Application by Highways England for an Order Granting Development Consent for A57 Link Roads

Deadline 9 - response on behalf of High Peak Borough Council

**LEGEND**

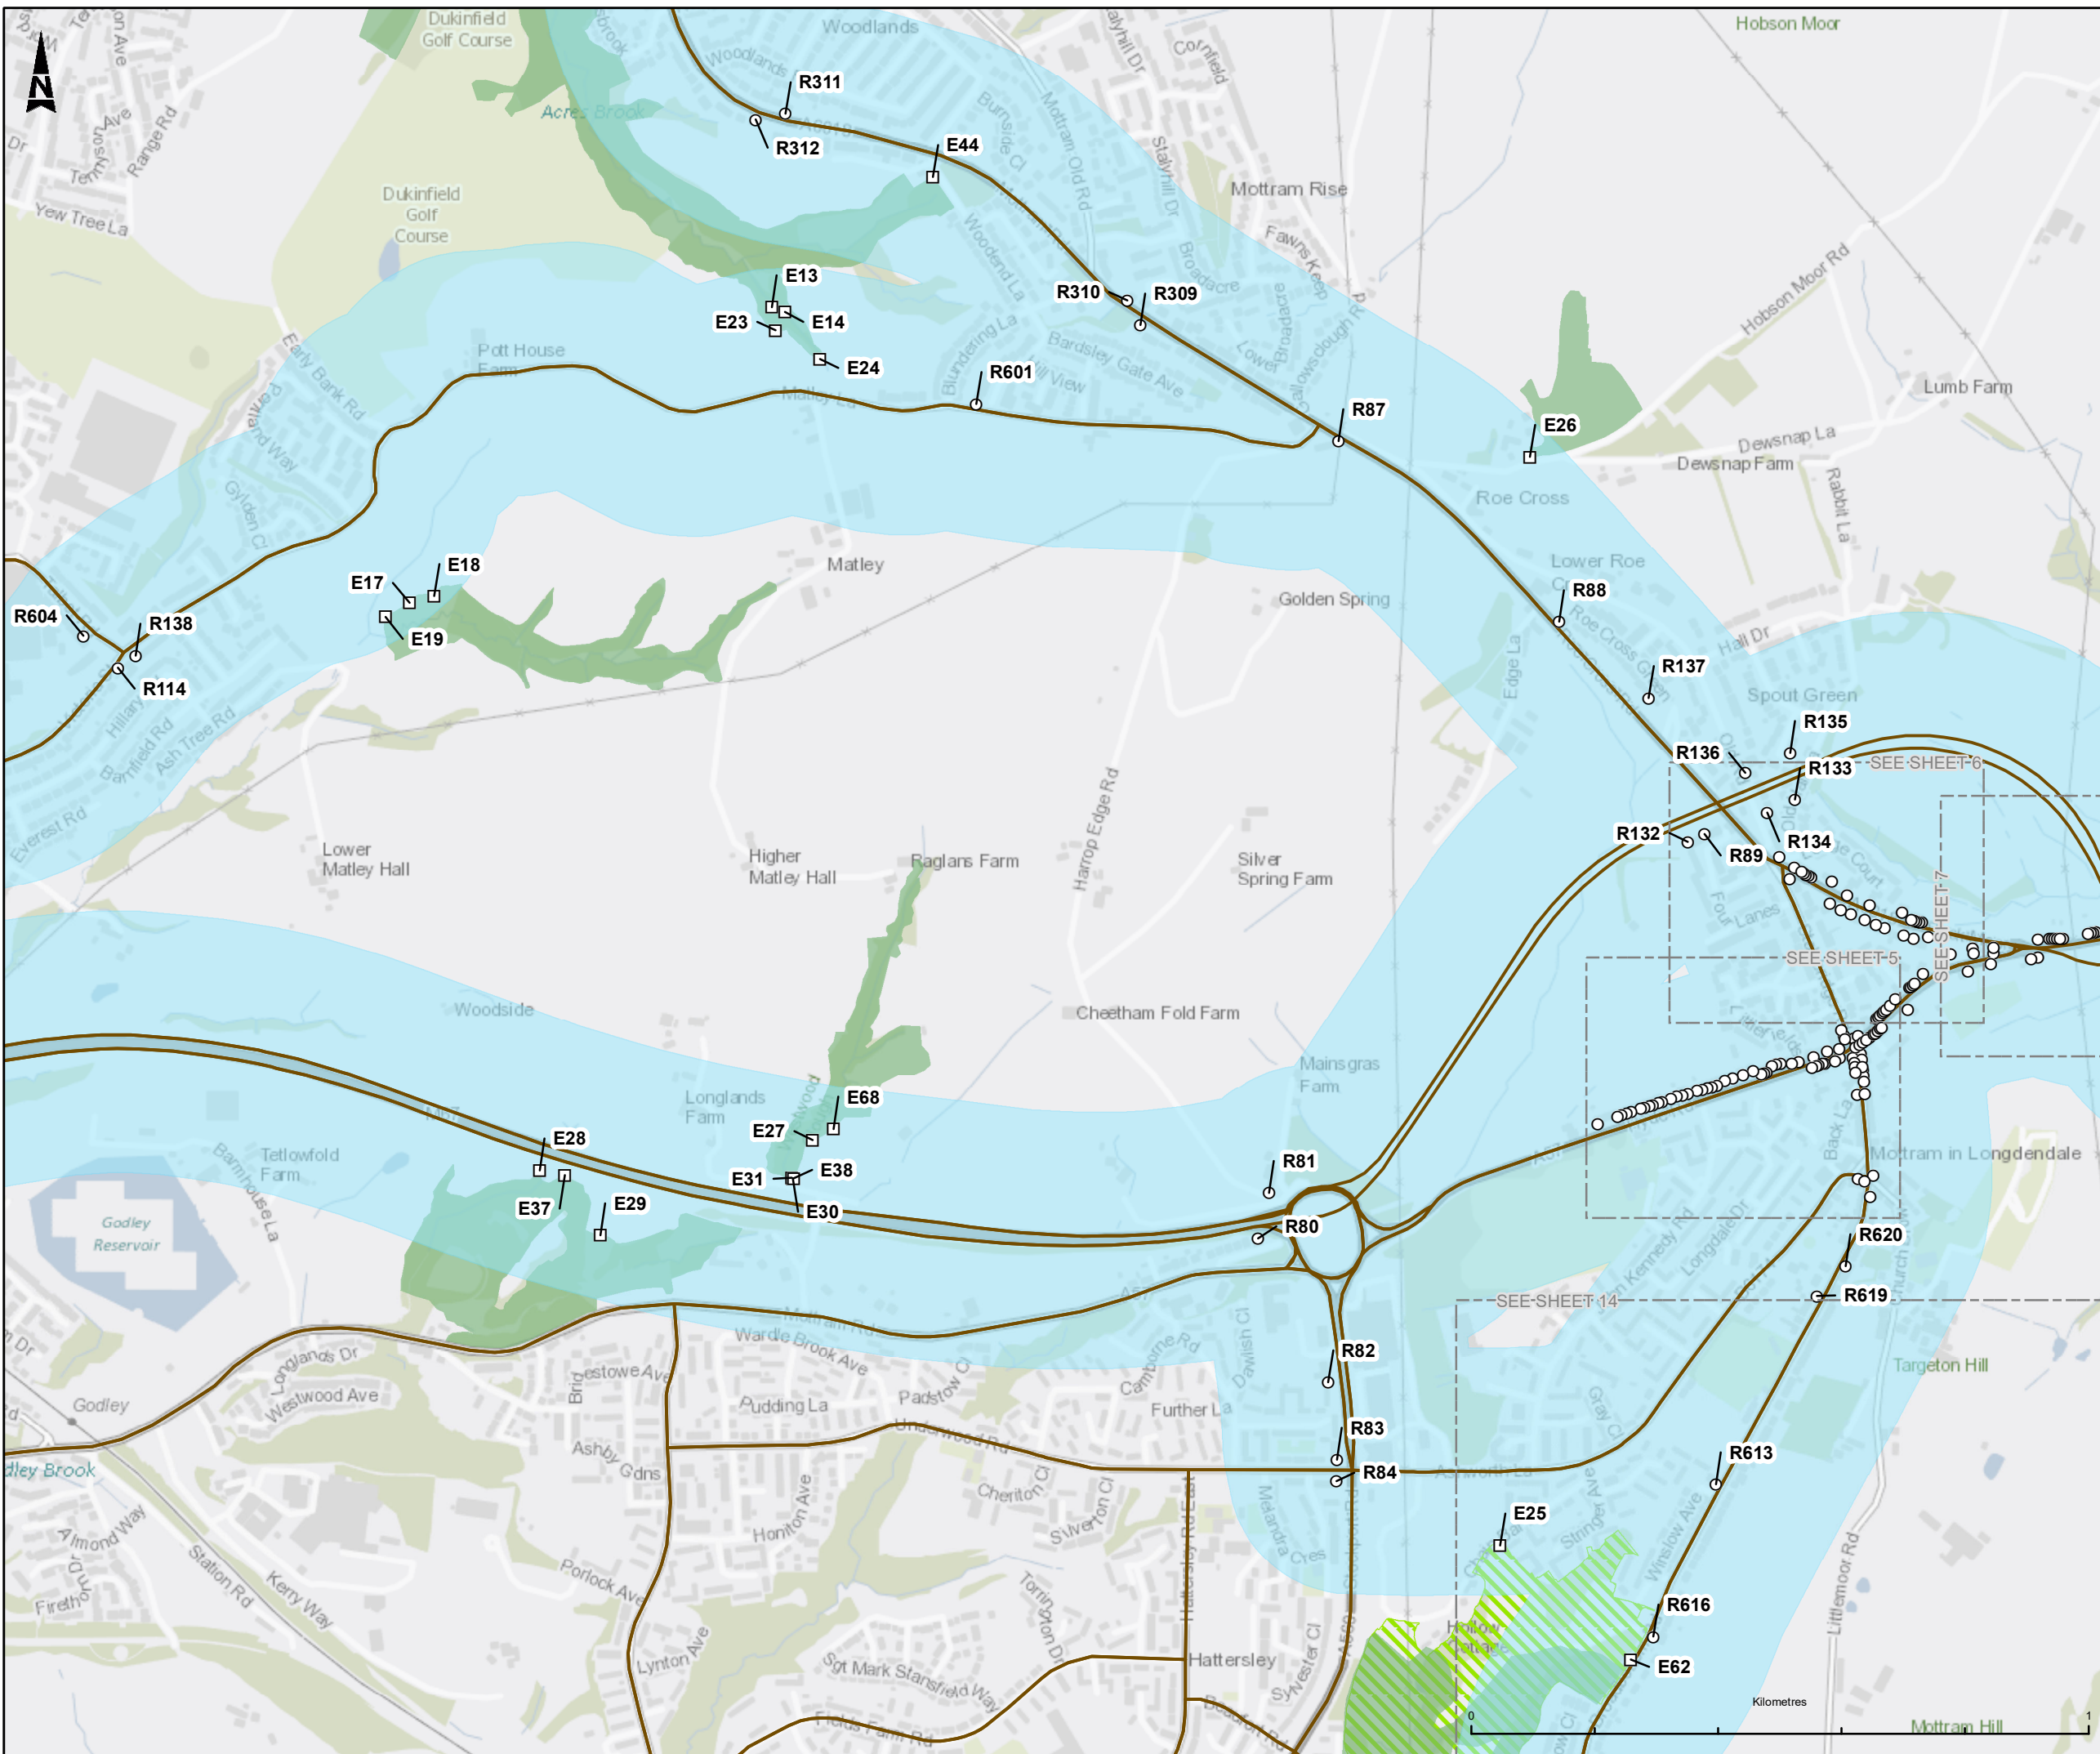
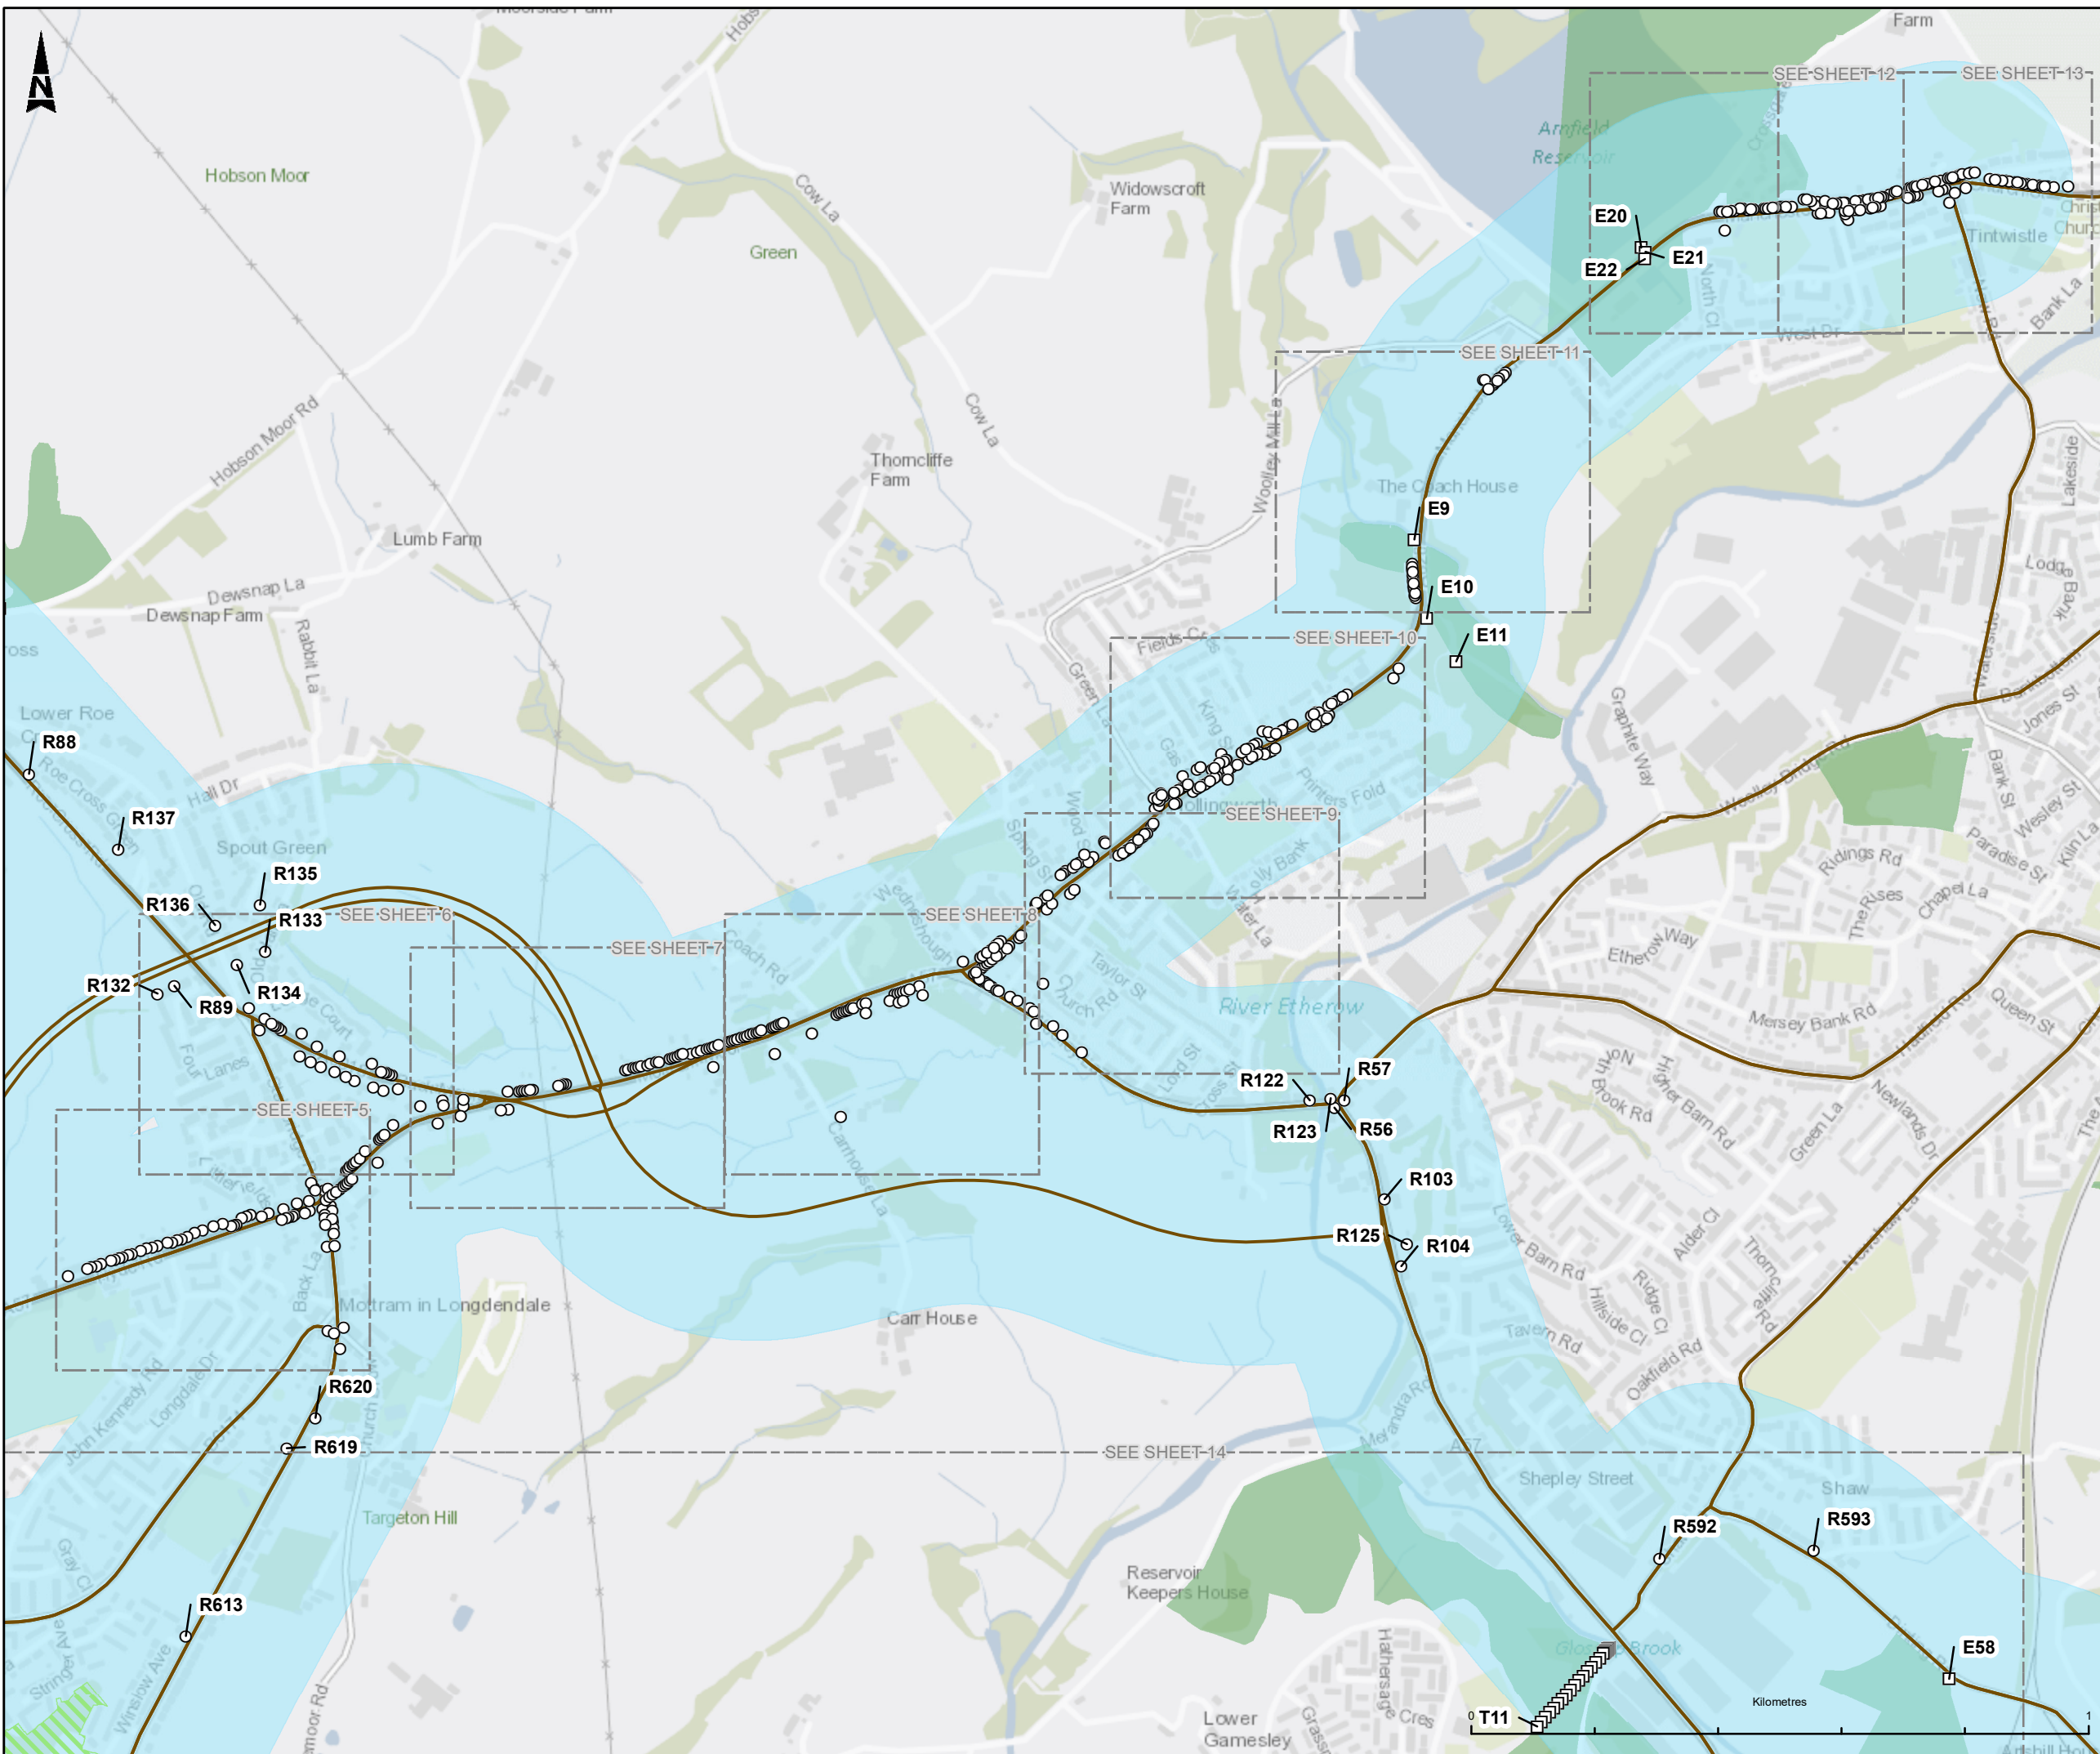
- *“The outcomes of the air quality assessment indicate there would be significant improvement in terms of annual mean NO2 concentrations at sensitive, human health receptors within the air quality study area. The Scheme will deliver improved air quality for all but one local receptor.”*

At the time of writing, the applicant has failed to properly assess the impacts of the scheme on the Air Quality Management Areas at Dinting and Tintwistle. As such, claims regarding significant improvements to air quality at sensitive human health receptors cannot be verified.
